**415 Cumberland Avenue**

After looking at your submission for 415 Cumberland Avenue, we've determined we need additional / updated materials. We will need to receive these before we can formally review or provide comments about your proposed project. Please provide:

Sheet Title:	<b>SITE PLAN</b>
--------------	------------------

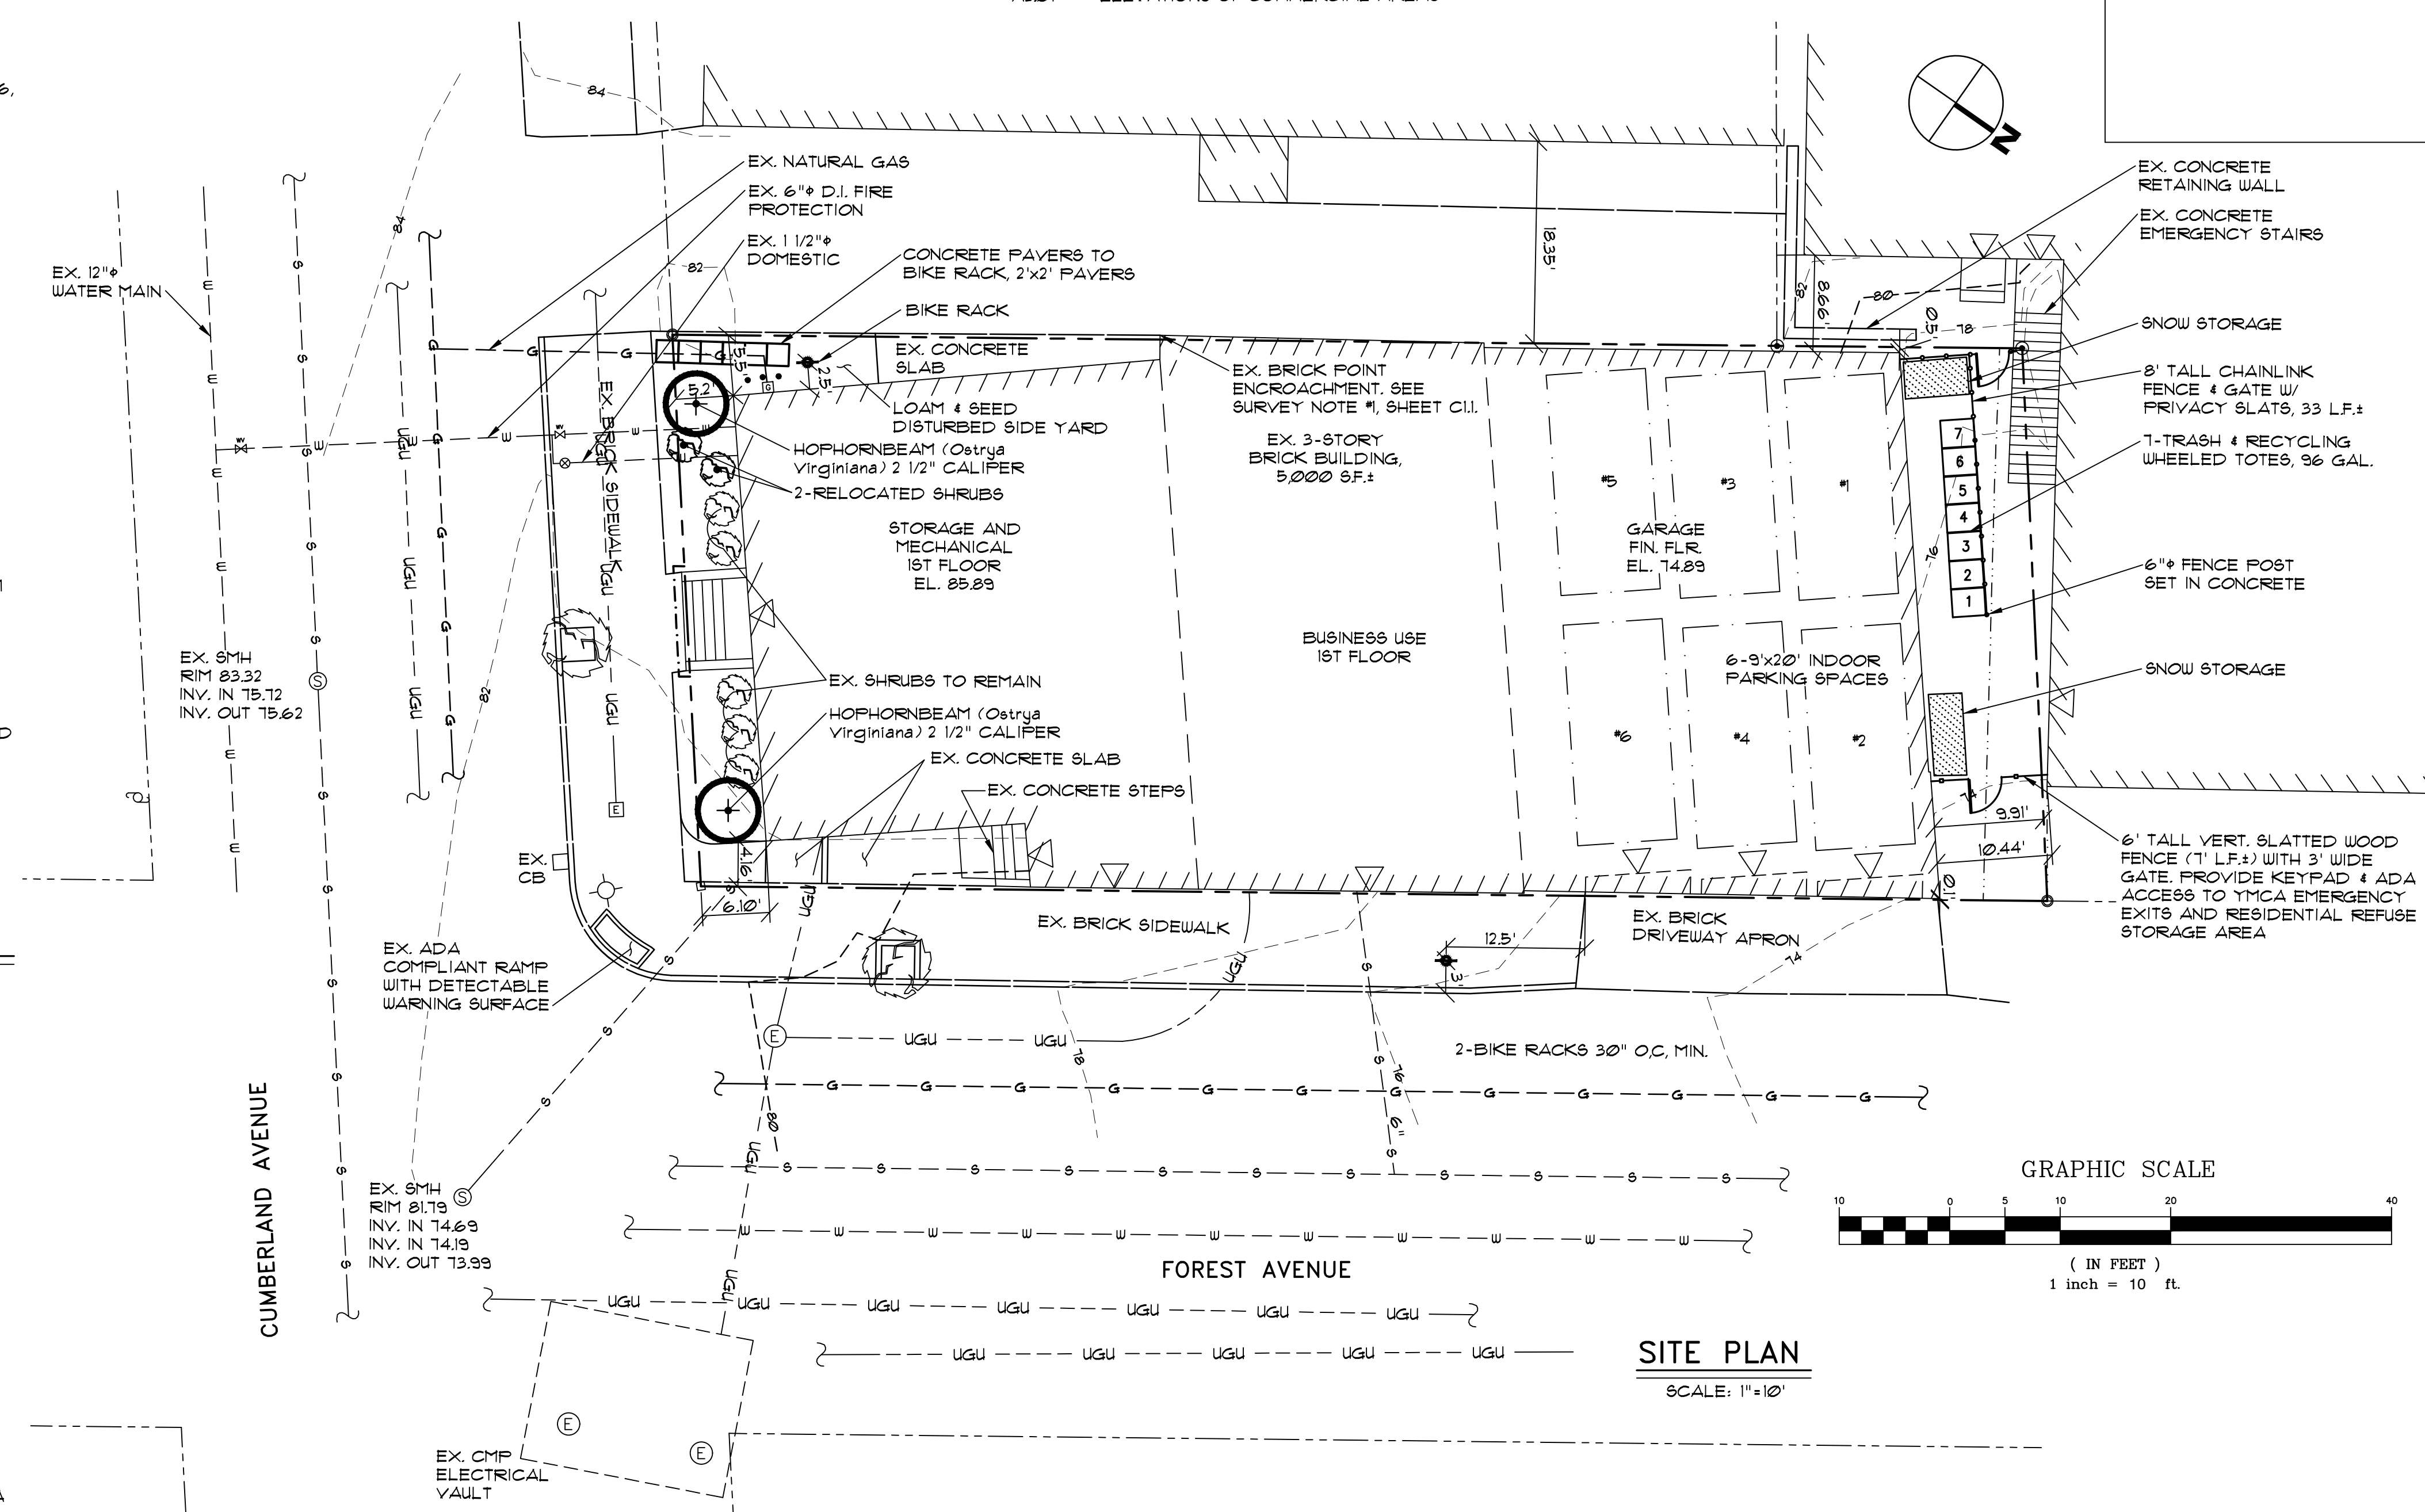
Without getting into formal comments, I also want to acknowledge that there seem to be some missing labels and/or mislabeled information on the plans you submitted. Some items that need attention / clarity include:

- * there is a walkway crossing the sidewalk near the front entrance of the building, the purpose of which is unclear. (Are these to bicycle hitches? If so, the hitches are unlabeled)
- * location of the trash
- * access easement for the YMCA
- * allocation and management of parking
- * uses of commercial space
- * use of deck space (is this unit part of the unit below, which is labeled a 2 bedroom?)
- * traffic signal pole misidentified as light pole
- * existing street trees on Cumberland and Forest Avenues
- * gate off Forest Avenue access/ egress / placement /details do not appear on site plan

That you for the comments. We will address them. Please note the subdivision plan is stamped by the surveyor. He embossed the originals. Also we will change the name on the landscape plan to the Site Plan. It shows all of the work that we are doing.

The plans have been updated. Please note the Landscaped Plan C1.2 is null and void. Please delete it from the site or make sure the reviewers know it is not part of the review set. An explanation of the zoning and code analysis was included noting what we need to do to comply with the ADA aspects of the project.
